**Consultation Response from KC,
Conservation & Design**

2025/92443 & 2025/92444 Huddersfield Open Market, Brook Street, Huddersfield, HD1 1DY

Date Responded:12/12/25

DRAWING Typical ASHP Rejection Unit Enclosure Design Intent

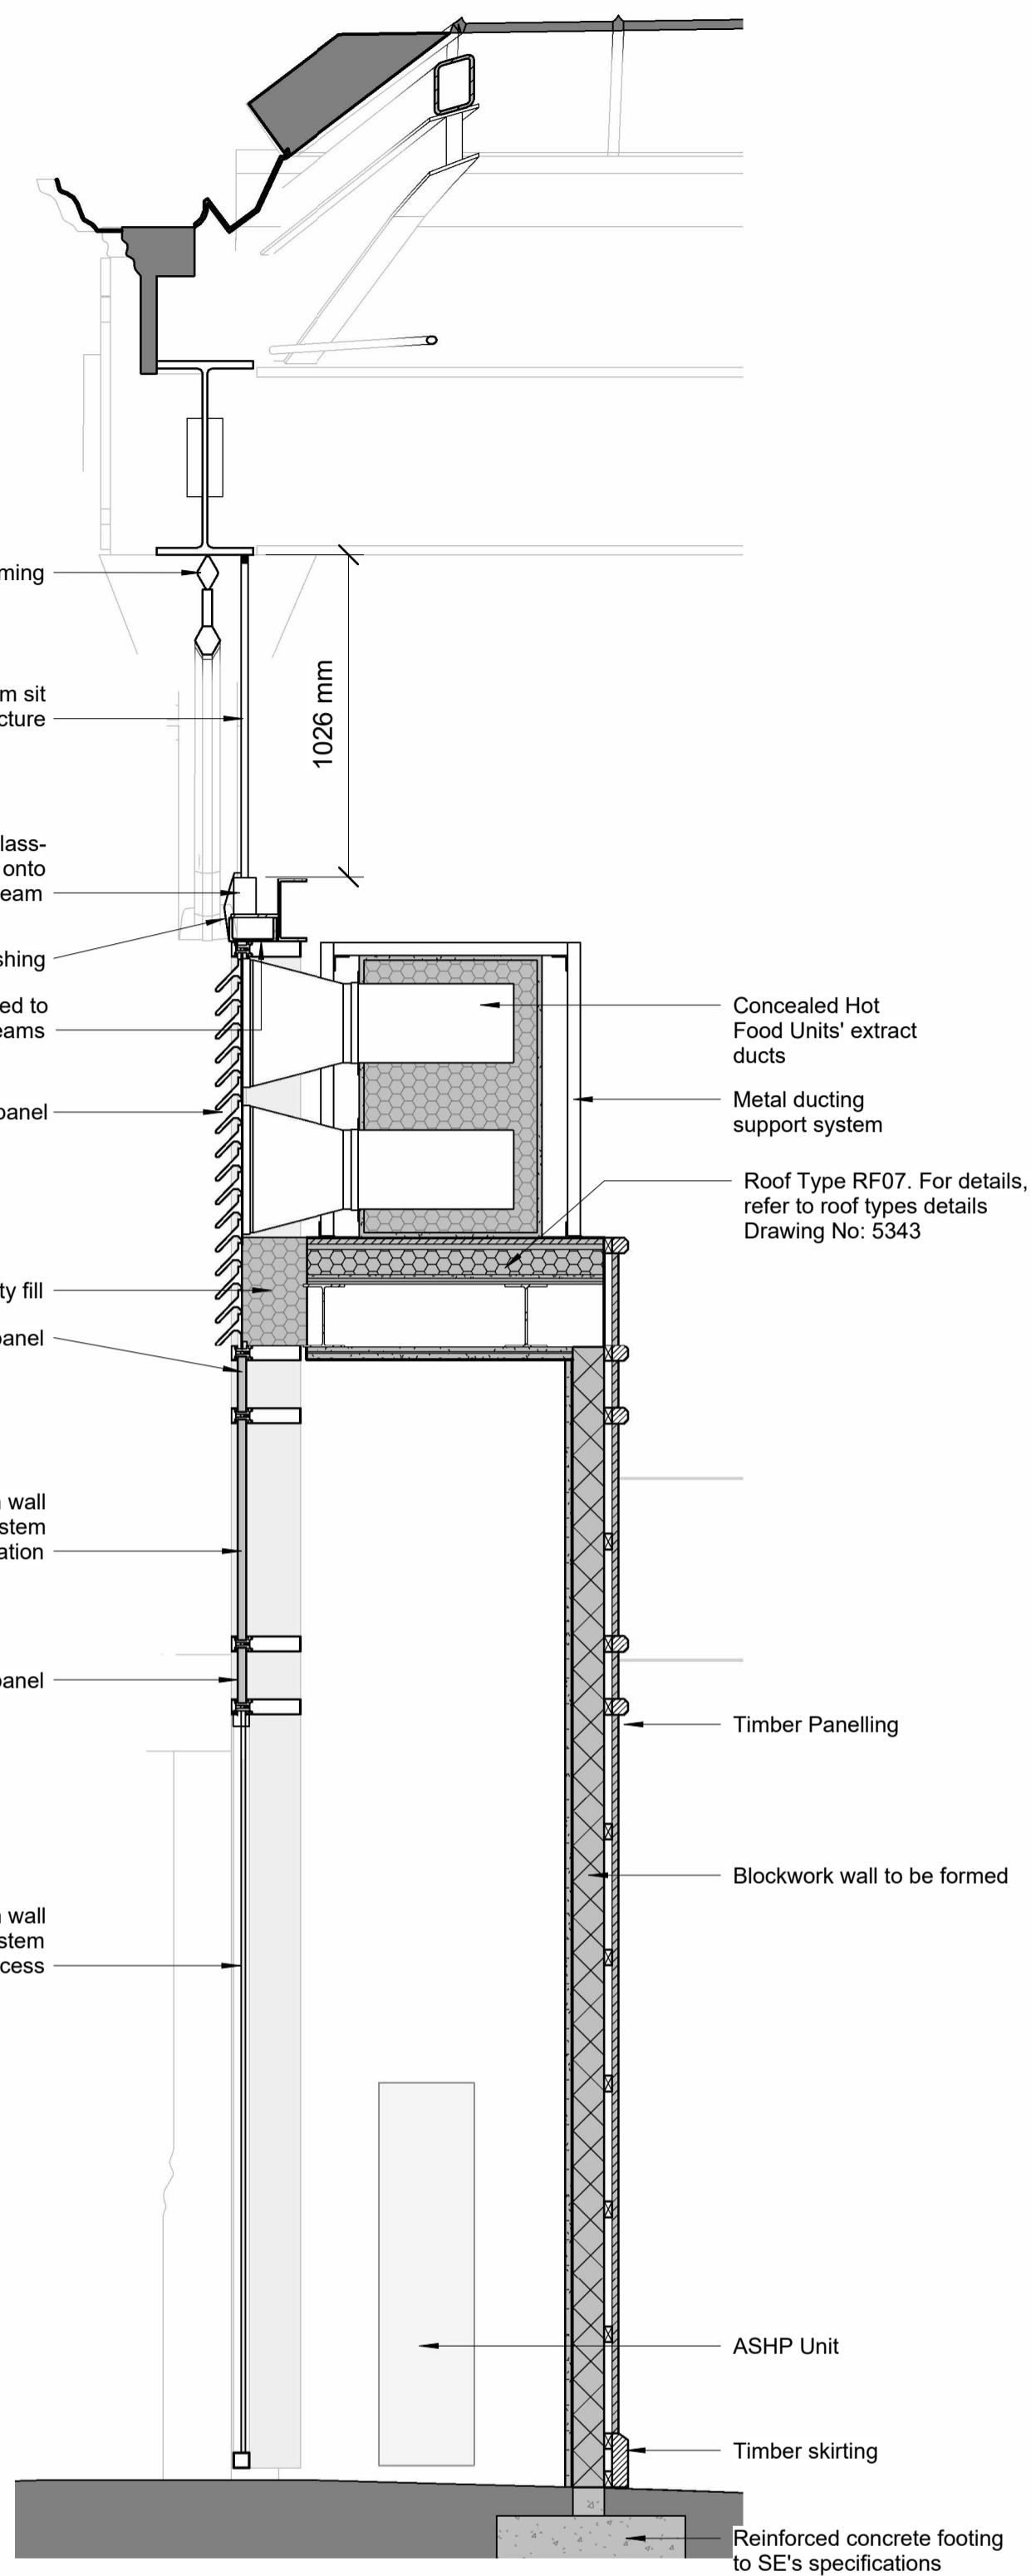
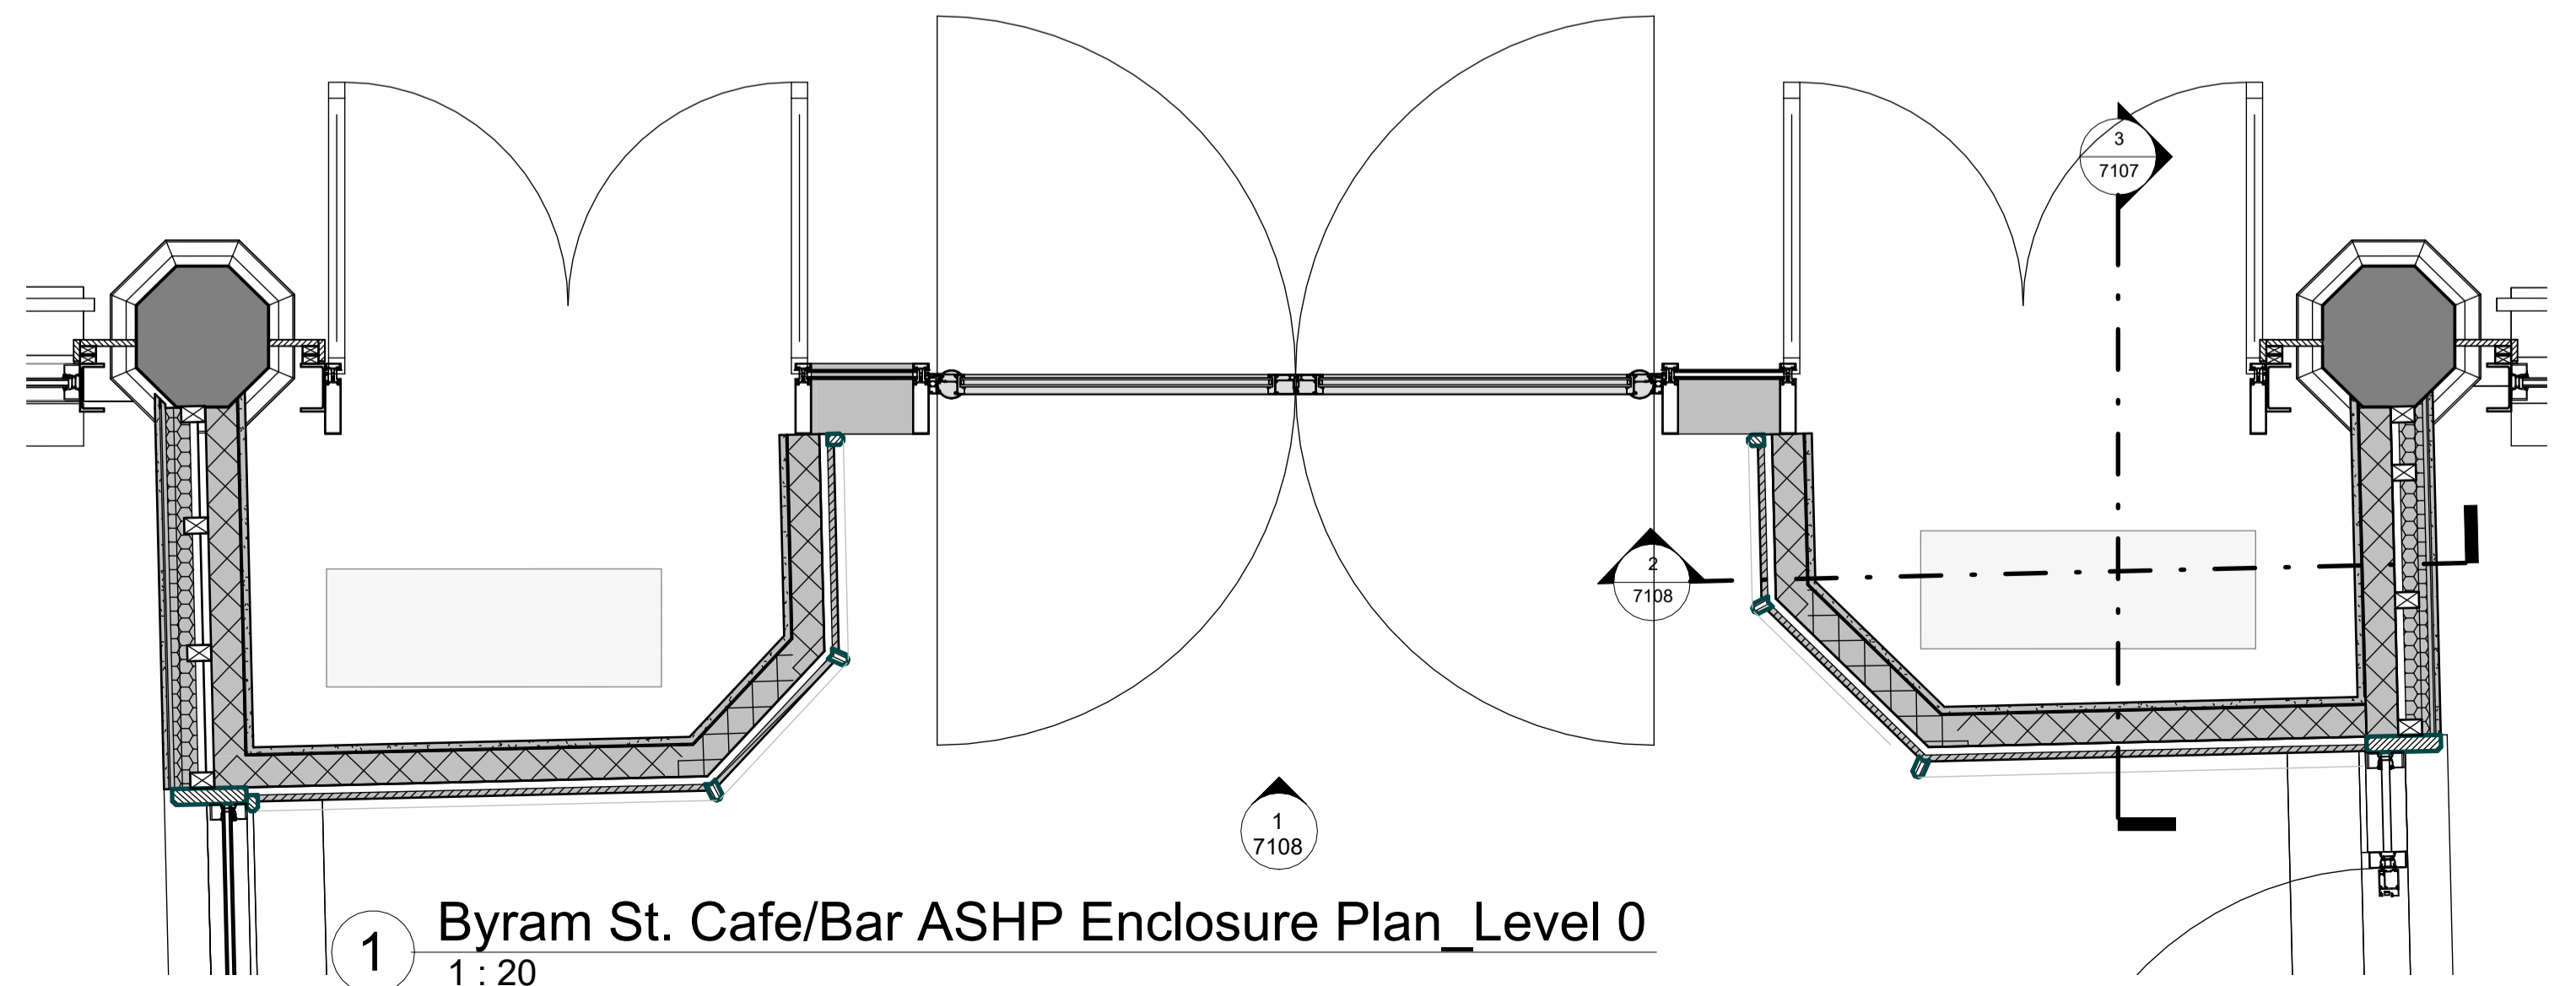
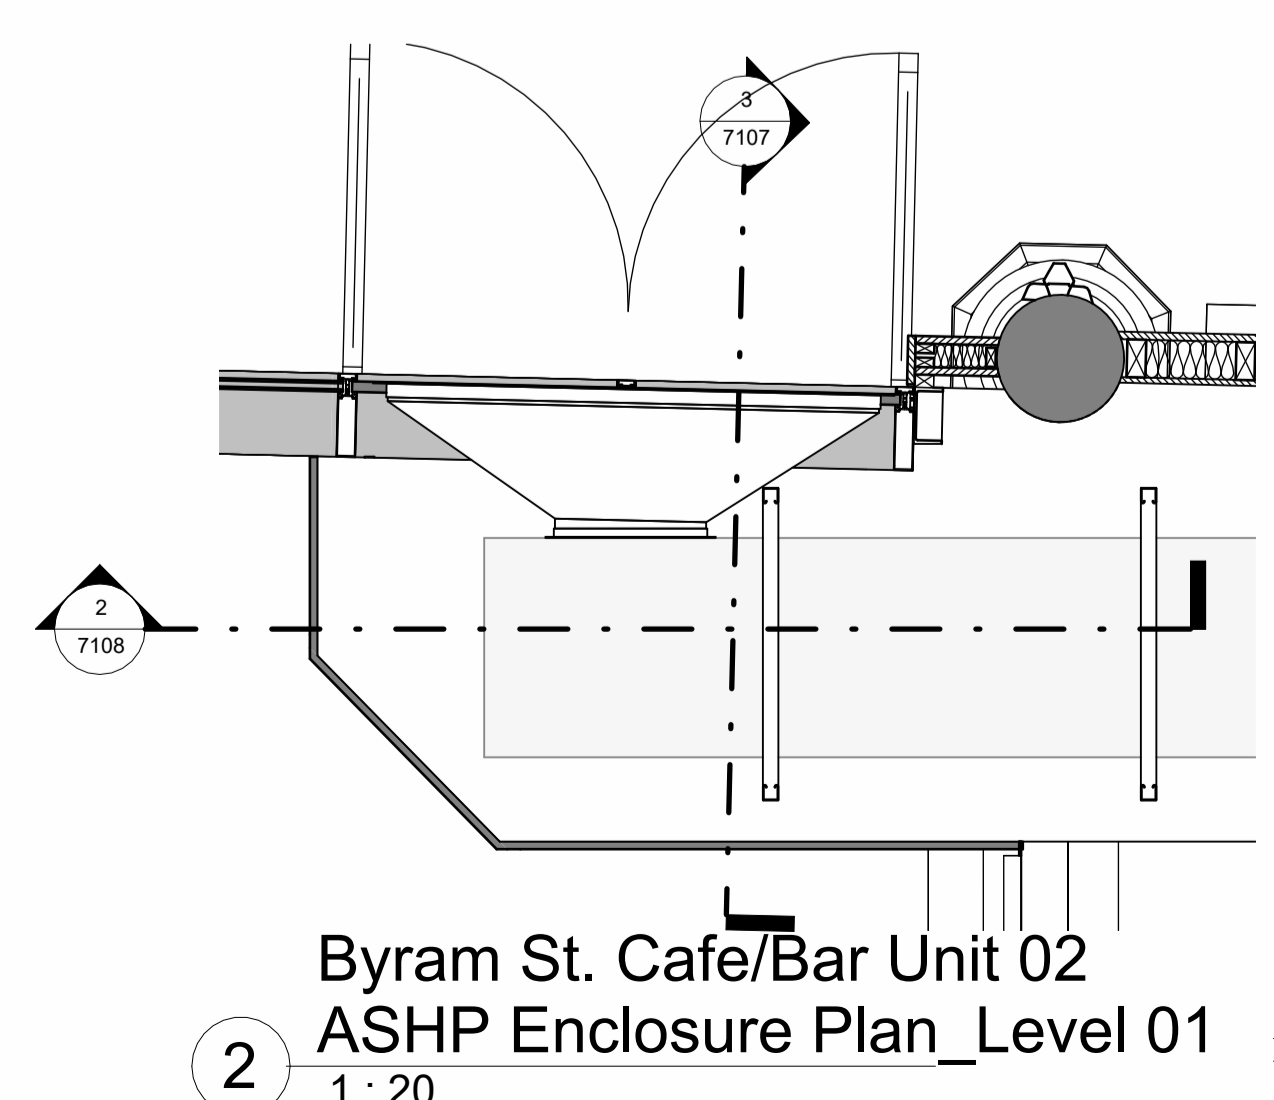
Further details should be submitted in due course, which could be conditioned, to confirm details of materials eg perforated metal curtain wall panels to allow for ventilation shown on the Typical ASHP Rejection Unit Enclosure Design Intent Plans, materials used in the hard landscaping and street furniture.

DRAWING  
Public Realm Proposed Plan with surface finish areas

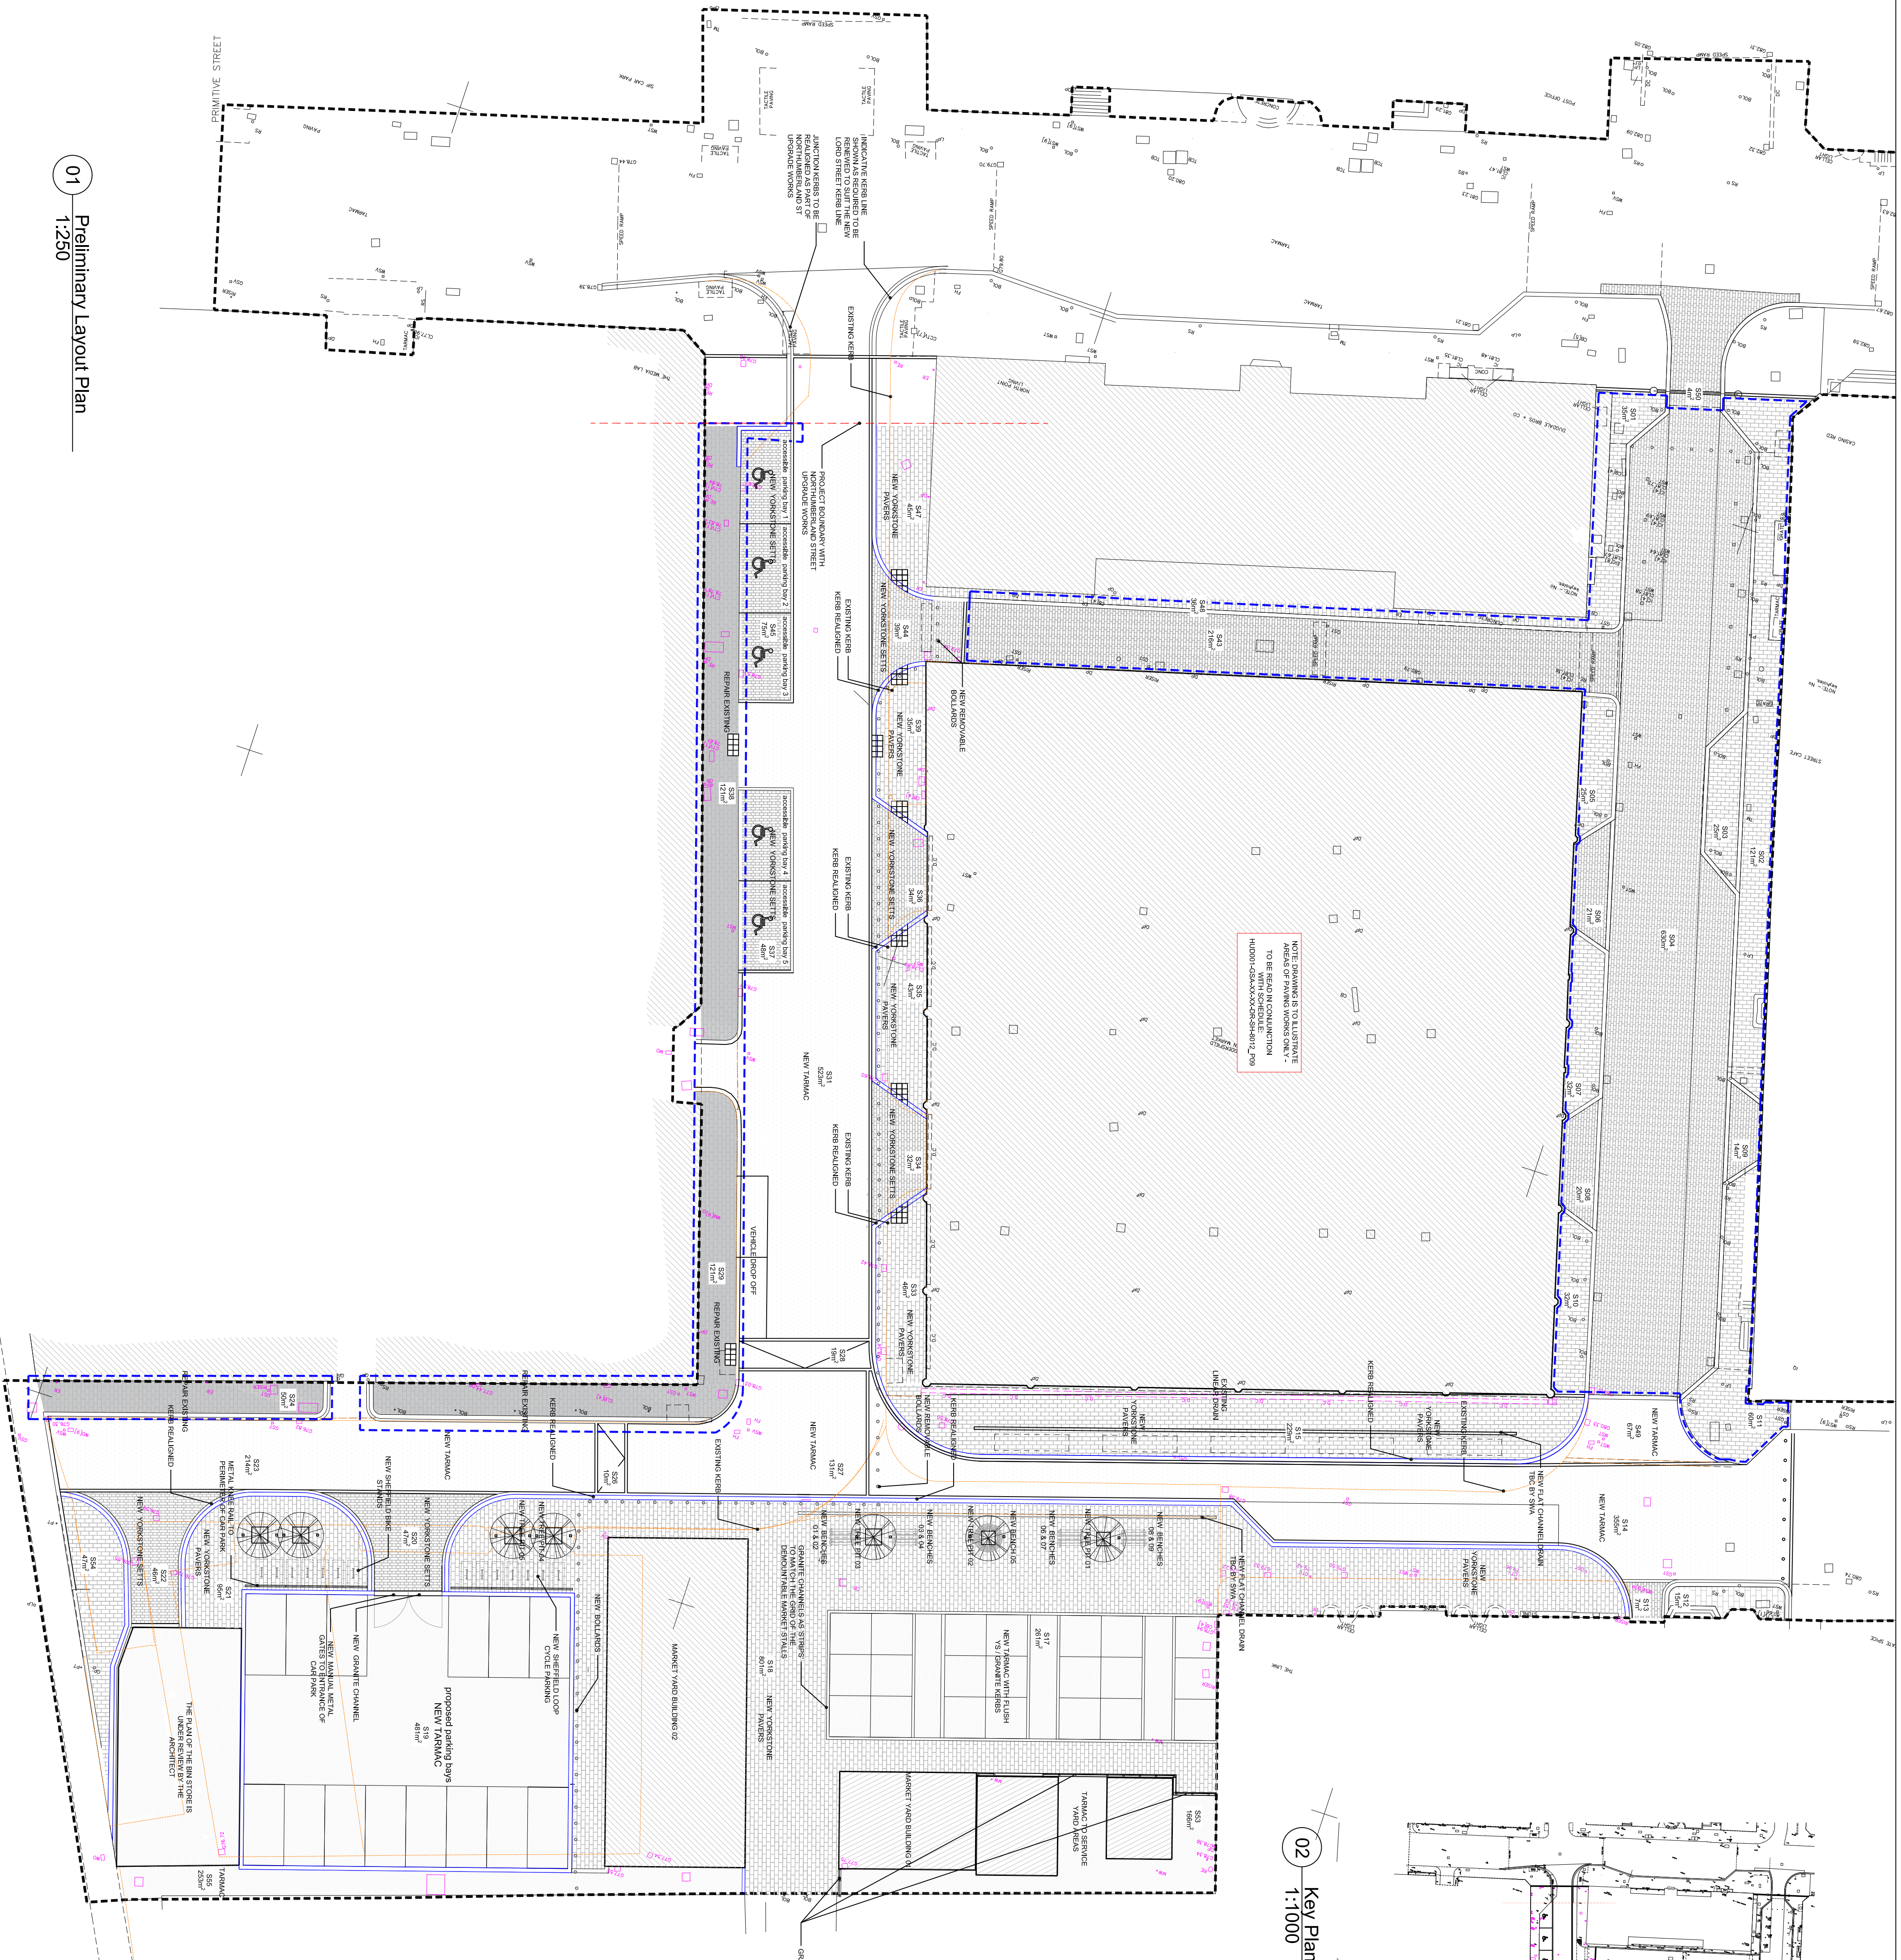
Enhancement of the outdoor public realm space is welcomed. We would encourage the retention of any natural stone materials and use of new natural stone where possible or the use of a similar colour

palette, texture and finish materials eg buff colours or greys are preferred to fit in with the strong local distinctiveness of the area, rather than red materials. This appears to be the theme for the proposals currently. Use of soft landscaping, appropriate street furniture and lighting would enhance the area with the new demountable outdoor stalls.
